601 CENTRAL AVE NE
+
501 CENTRAL AVE NE
RESPONSE TO SKETCH PLAT
COMMENTS

Integrated Design & Architecture
Meeting Date: March 20, 2024

PROPOSED SITE PLAN

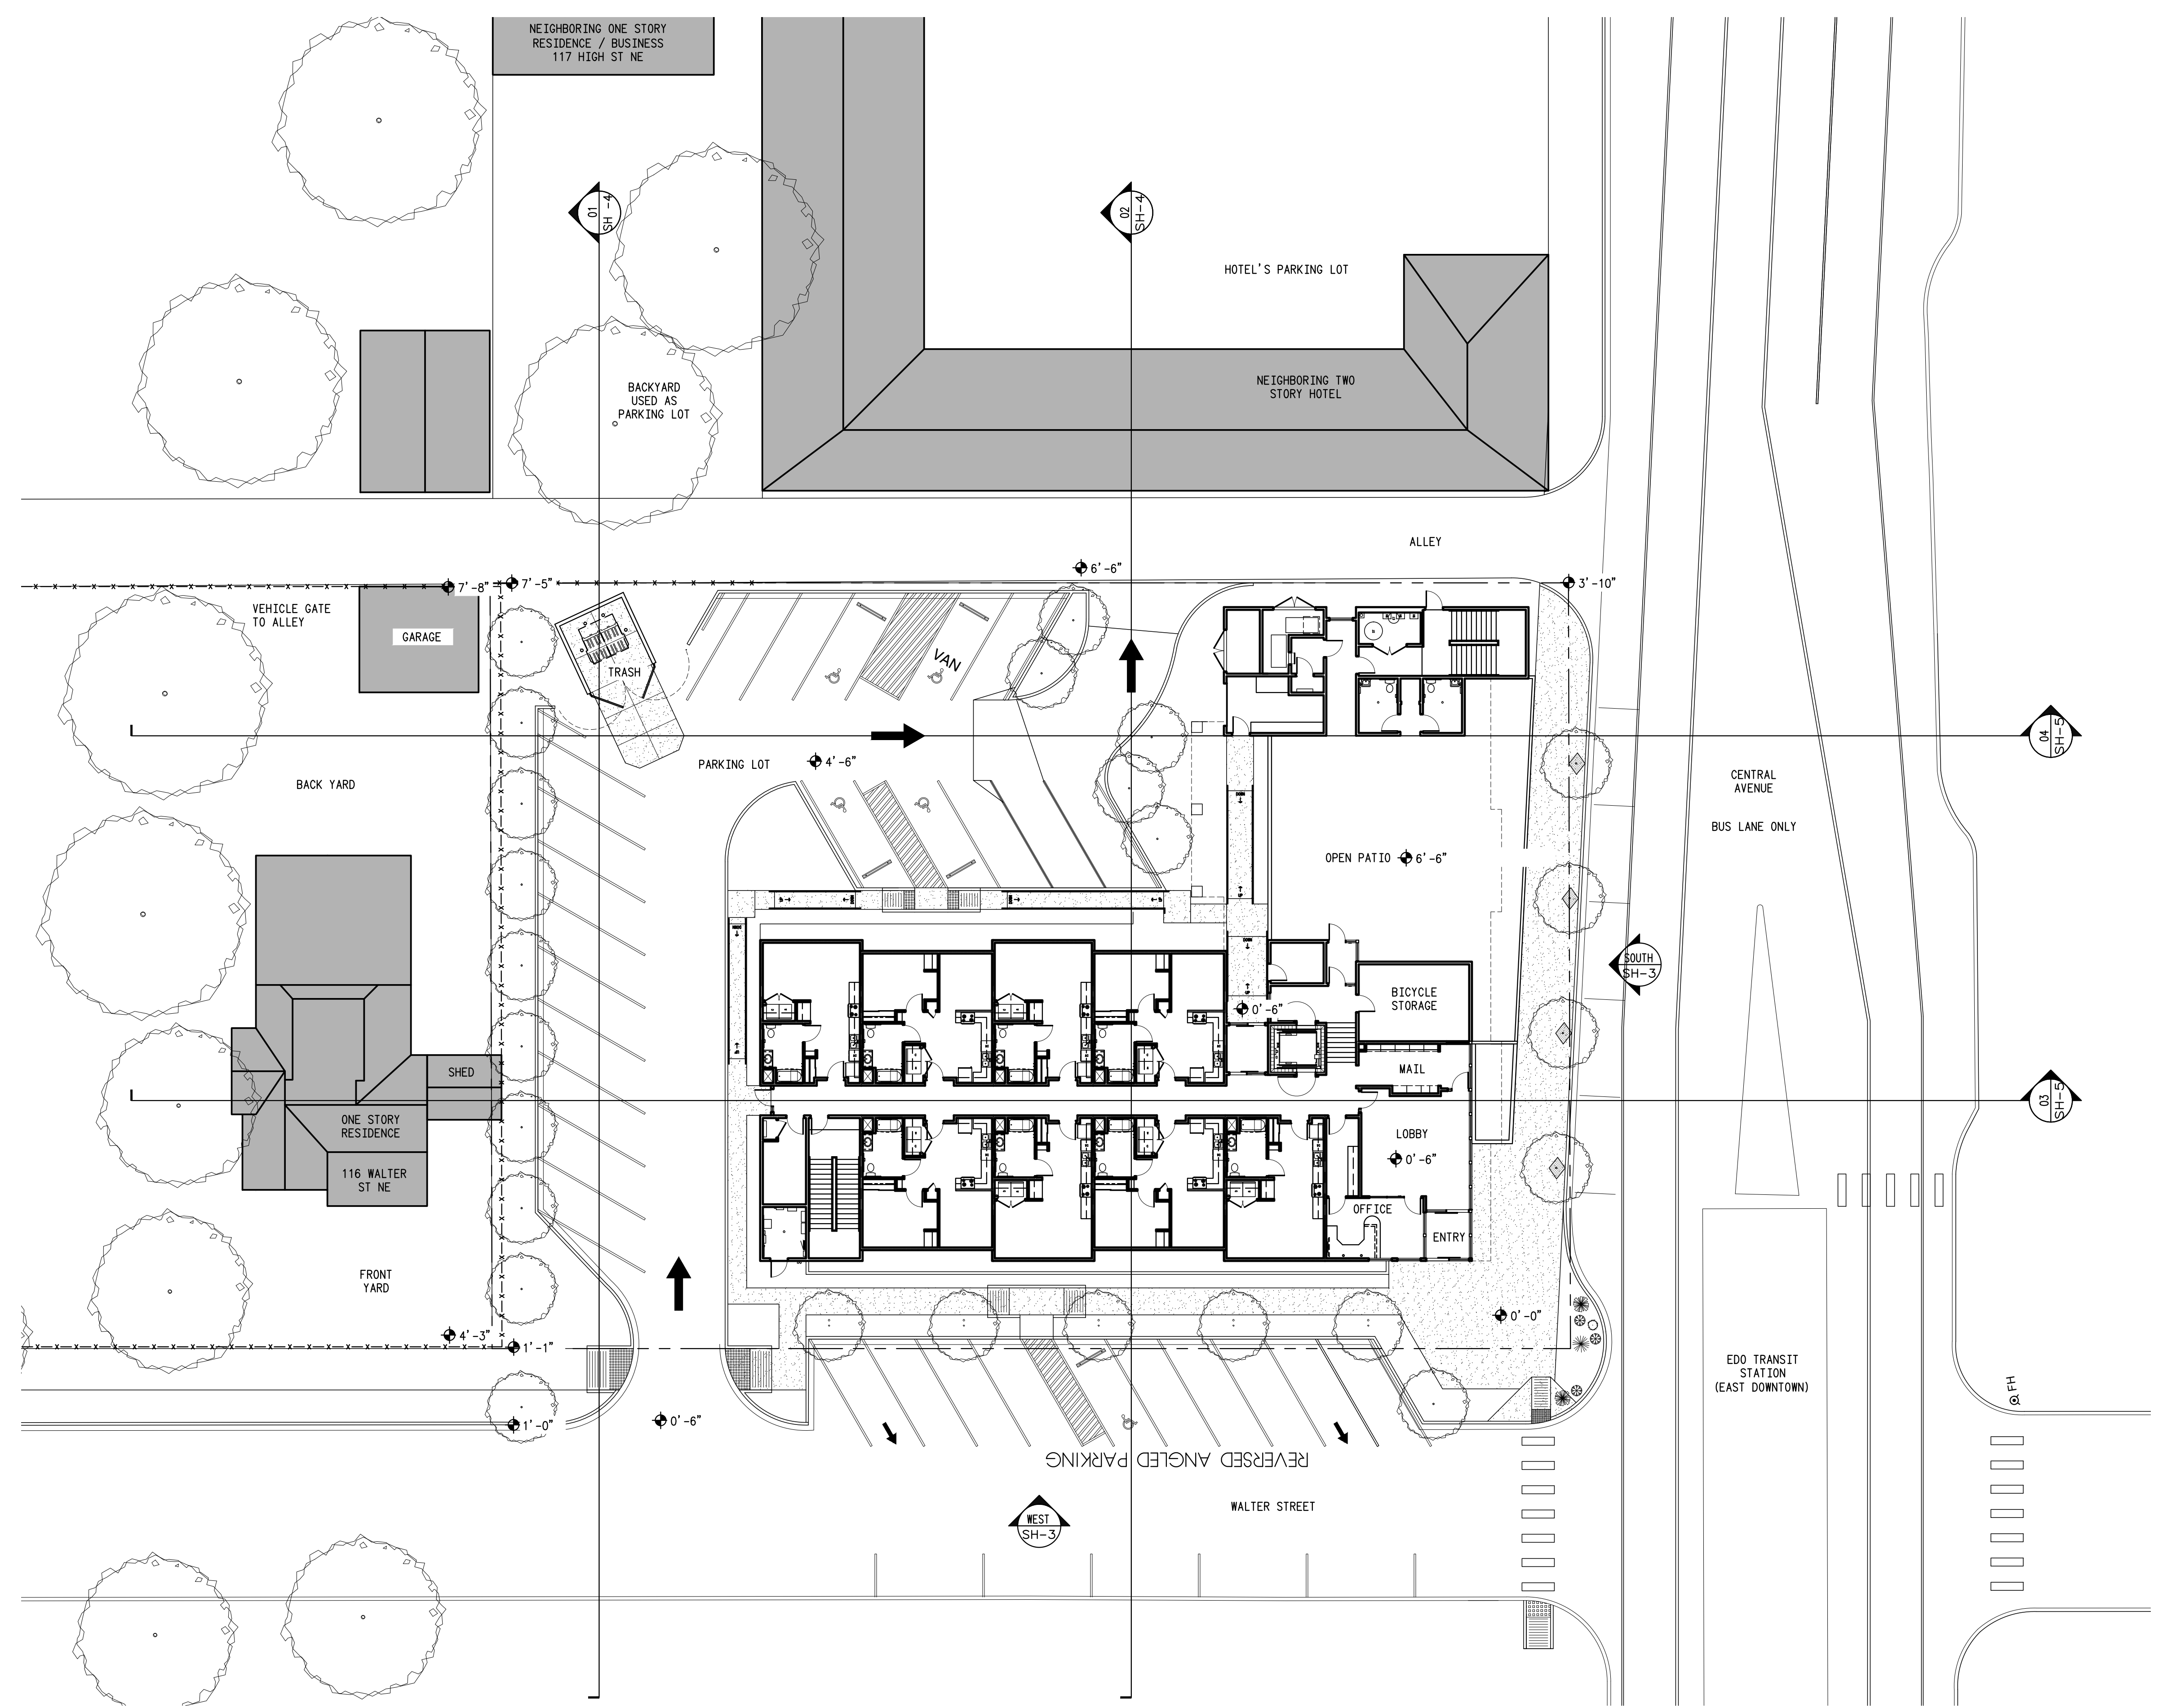
Required Parking: 68 Units x 1 Space / Dwelling Unit (UC-MS-PT) = 68 Parking Spaces

$$68 \times .30 = 20.4 = 21$$

$$68 \times .10 = 6.8 = 7$$

$$\text{Total Reduction} = 21 + 7 = 28$$

$$\text{Deviation: } 68 \times 0.05 = 3.4 = 4$$

$$\text{Required Parking} = 68 - 28 = 40 \text{ Spaces}$$

$$\text{Required Parking if Deviation is allowed} = 40 - 4 = 36 \text{ Spaces}$$

33 Spaces Total (5 Accessible, 28 Standard)

Variance Needed = 7 Spaces

Variance Needed if Deviation Allowed = 3 Spaces

BUILDING HEIGHT DIAGRAMS

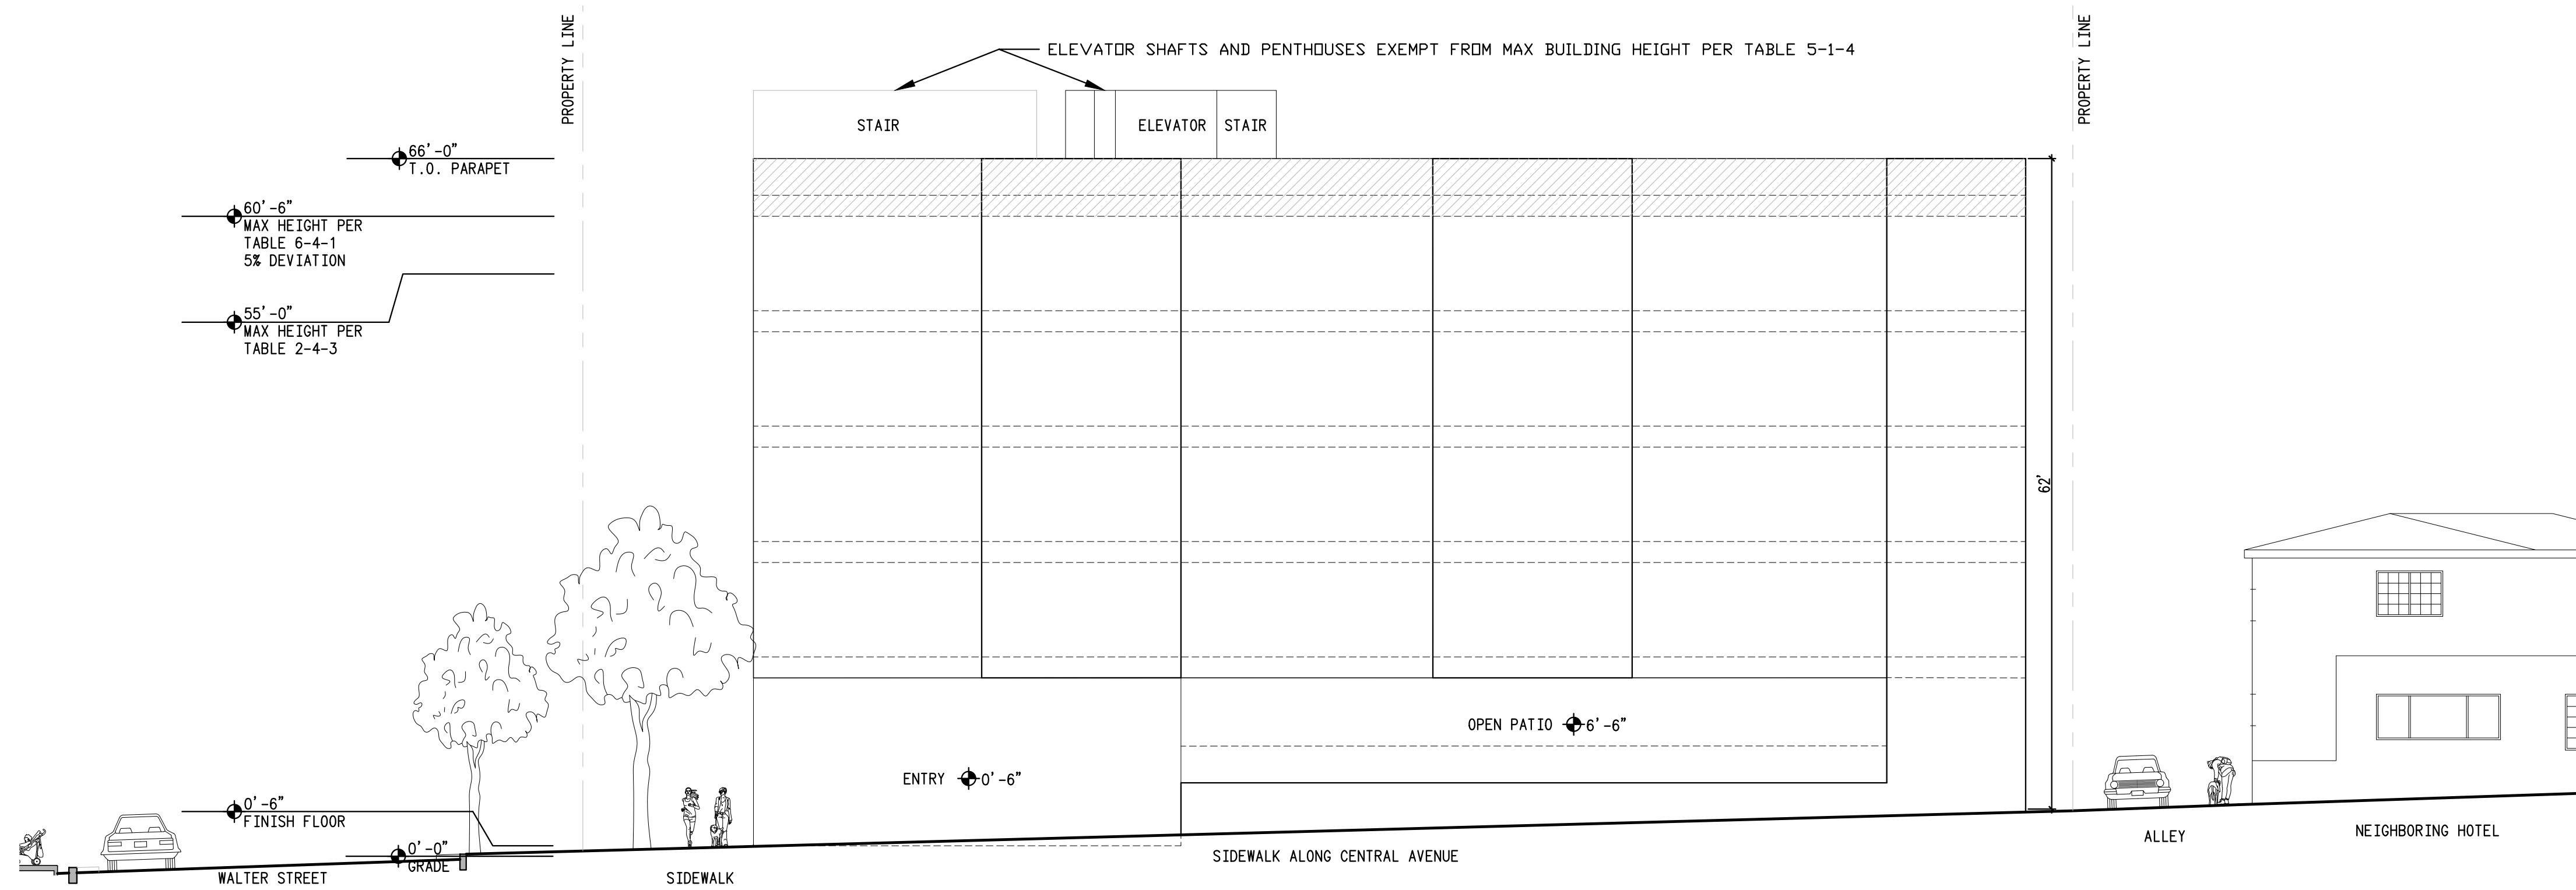
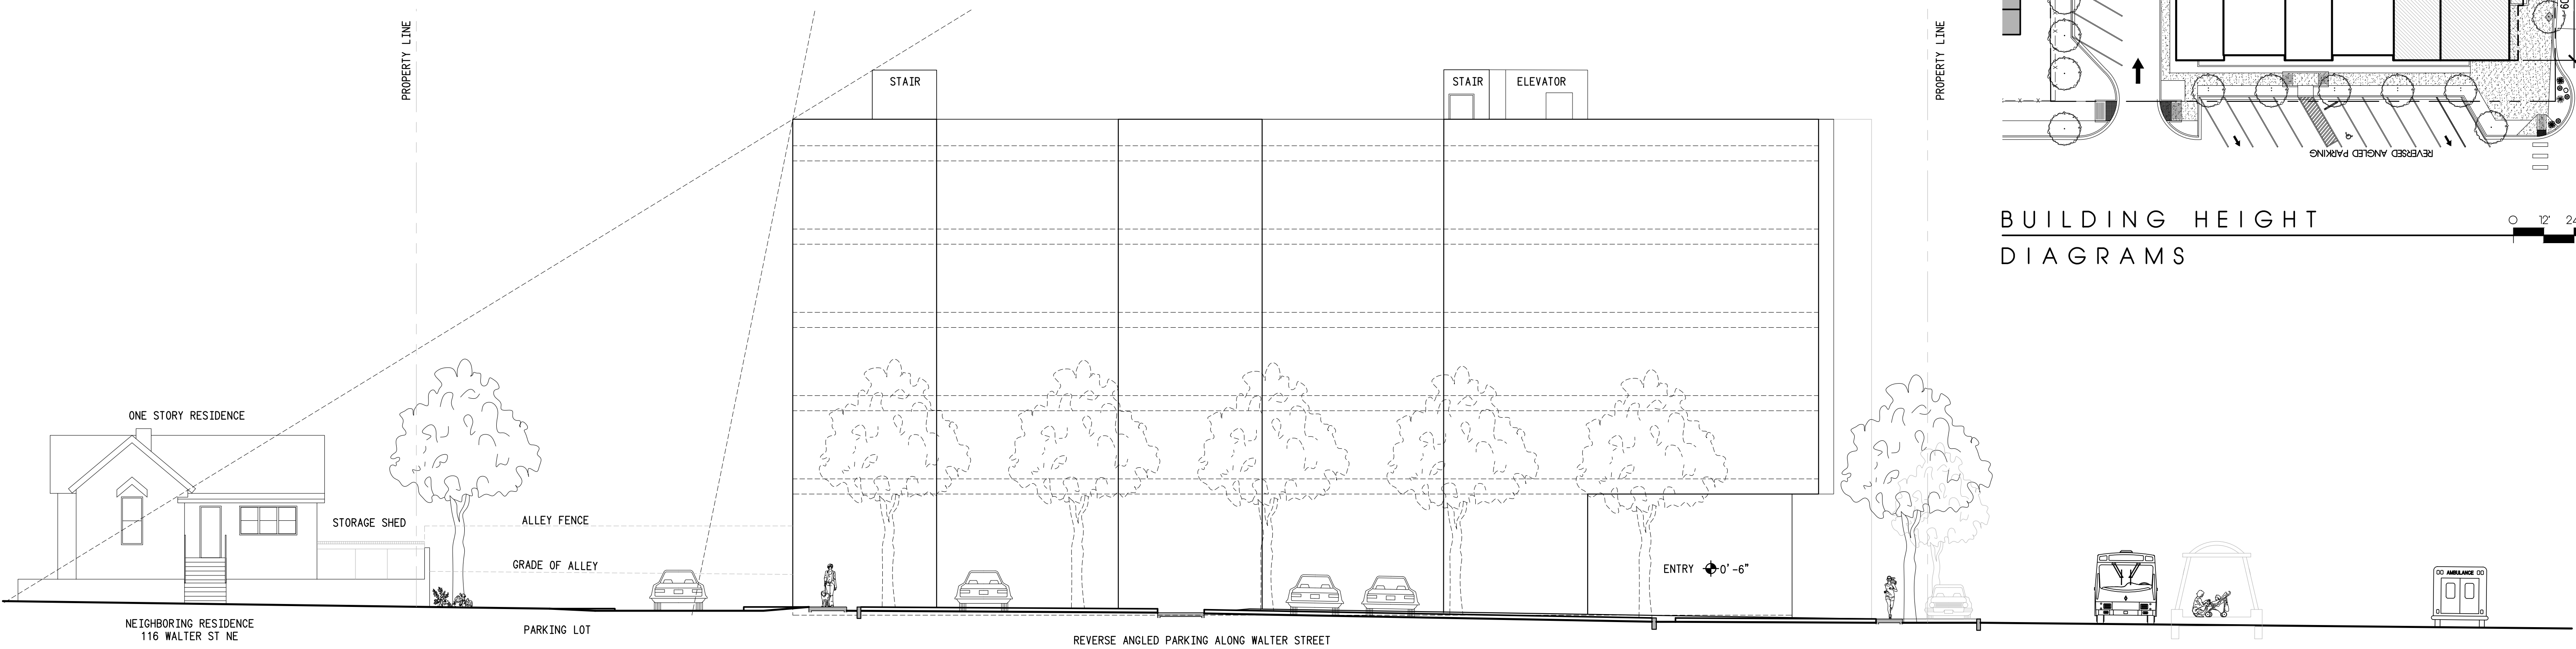
Discussion: Previous discussion (3/6/24): Cochetta discussed that the height of the building should be an average of two points. IDA mentioned they were looking at the height from the tallest portion of the building in terms of determining how much of a height variance they would need.

Question/Response: It is unclear to us what should be our “averaged finished grade” and what distinct segment of the building to take the height from when we go to ask for variance for height beyond the maximum 55 ft. What is considered a sloped site? Our site has a grade change of approximately 4 ft. along Central and 6 ft. along the north property edge running east to west. The site also slopes down from north to south. What is meant by “distinct segment”? We have two segments of the building because it is L-Shaped. Do we pick either since both would constitute 10% of the gross floor area? Is the average finished grade based on the entire site or just along the length of the facade of the “distinct segment”?
